**Preliminary Acceptance (PA) Punchlist**  
**EPC - DPW - Stormwater Section**

Project Name:	Hills at Lorson Ranch
EDARP Filing Number(s):	SF2110, PUDSP203, CDR207, PUDSP216
ESQCP Number:	ESQ2033
Attendees:	DPW SW: Natasha Grimaldo, Ben Jones, and Glen Reese DPW Planning: N/A Developer: Jeff Mark/Lorson LLC
Date of Walk-Thru:	11-06-2023
Walk-Thru Number:	4 <sup>th</sup>

**EXISTING POND C1 EXPANSION
POND GRADING AND
TRICKLE CHANNEL**

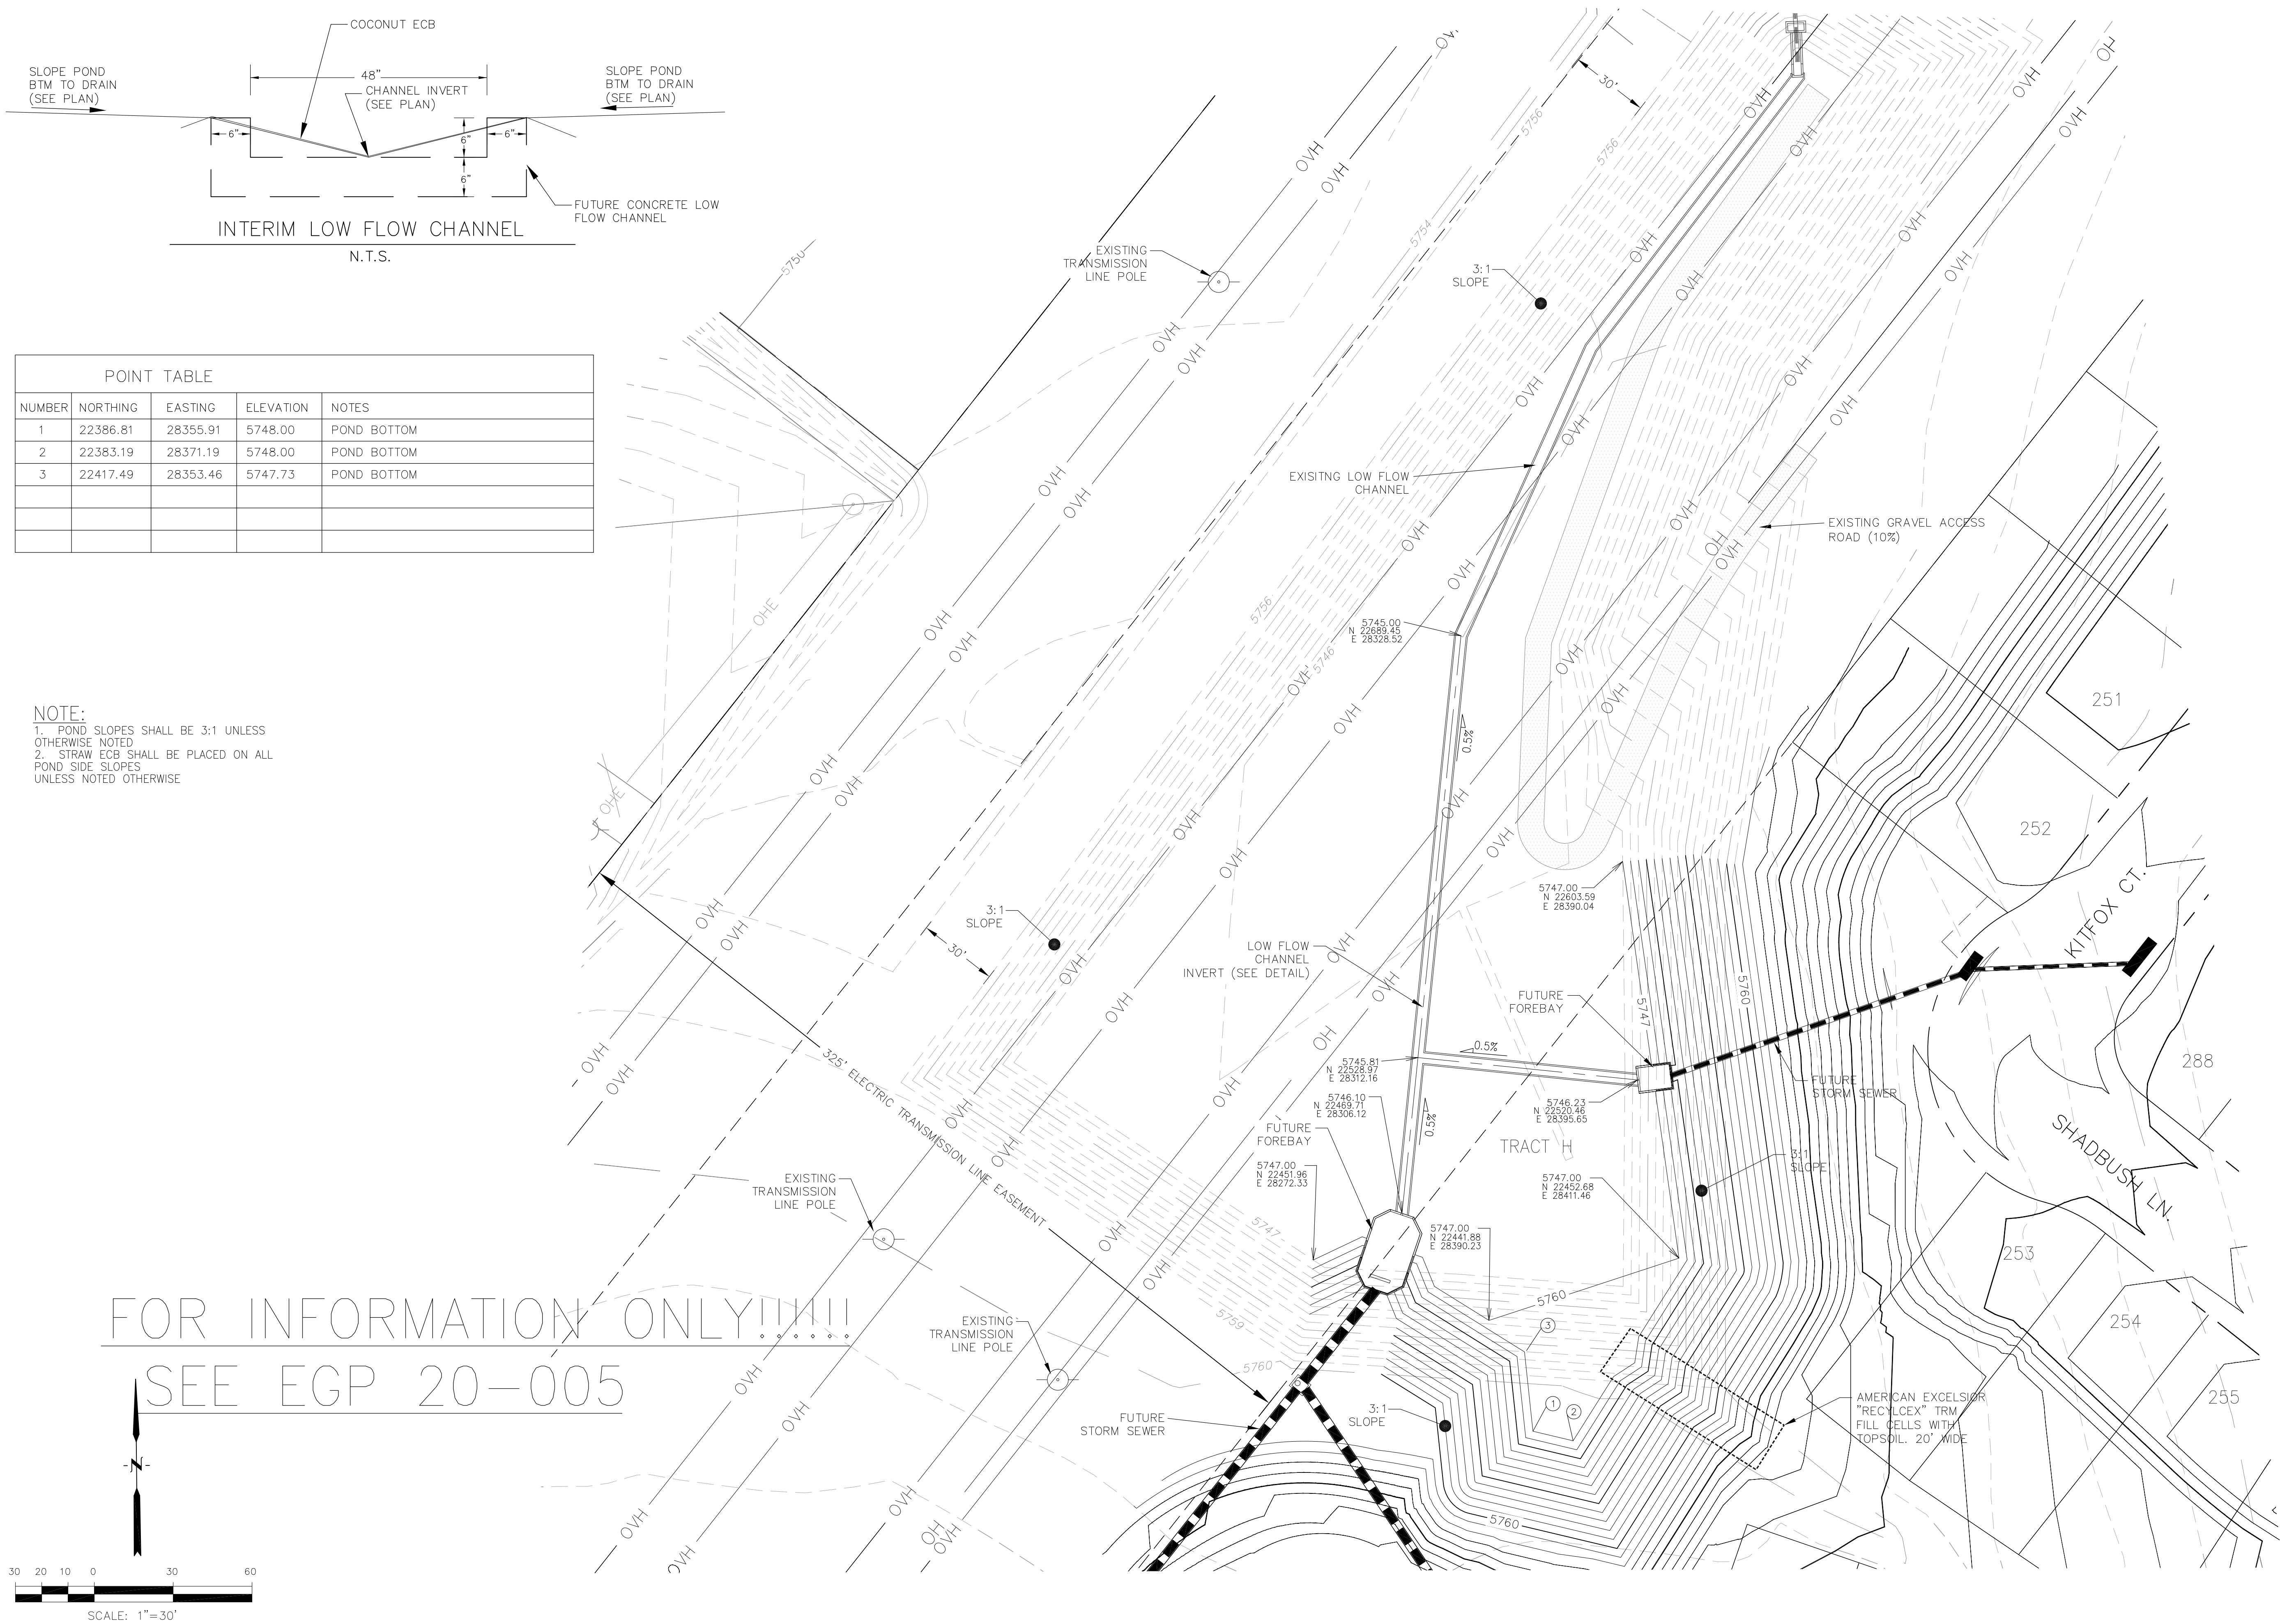
- ~~Remove sediment and debris from forebay 1 (SF 2110).~~
- **Repair crack in concrete where forebay 1 meets the trickle channel.** – Item to be verified once pond is cleaned.

- **Repair cracking at south forebay pipe entrance.** – Item to be verified once pond is cleaned.
- **Remove debris and sediment from trickle channel, outlet structure, micropool, and forebay.**

- **Grade pond bottom to match approved specs.**
- **Reinstall maintenance access road per plans. Plans call for 12" deep road base.**
- ~~Remove excess sediment and old straw wattles from trickle channel.~~

Photo 4: Pond C1: Repair crack in concrete where forebay 1 meets the trickle channel. Item will be checked once pond is cleaned.

Photo 5: Pond C1: Grade pond bottom to match approved specs and Reinstall maintenance access road per plans. Plans call for 12" deep road base.
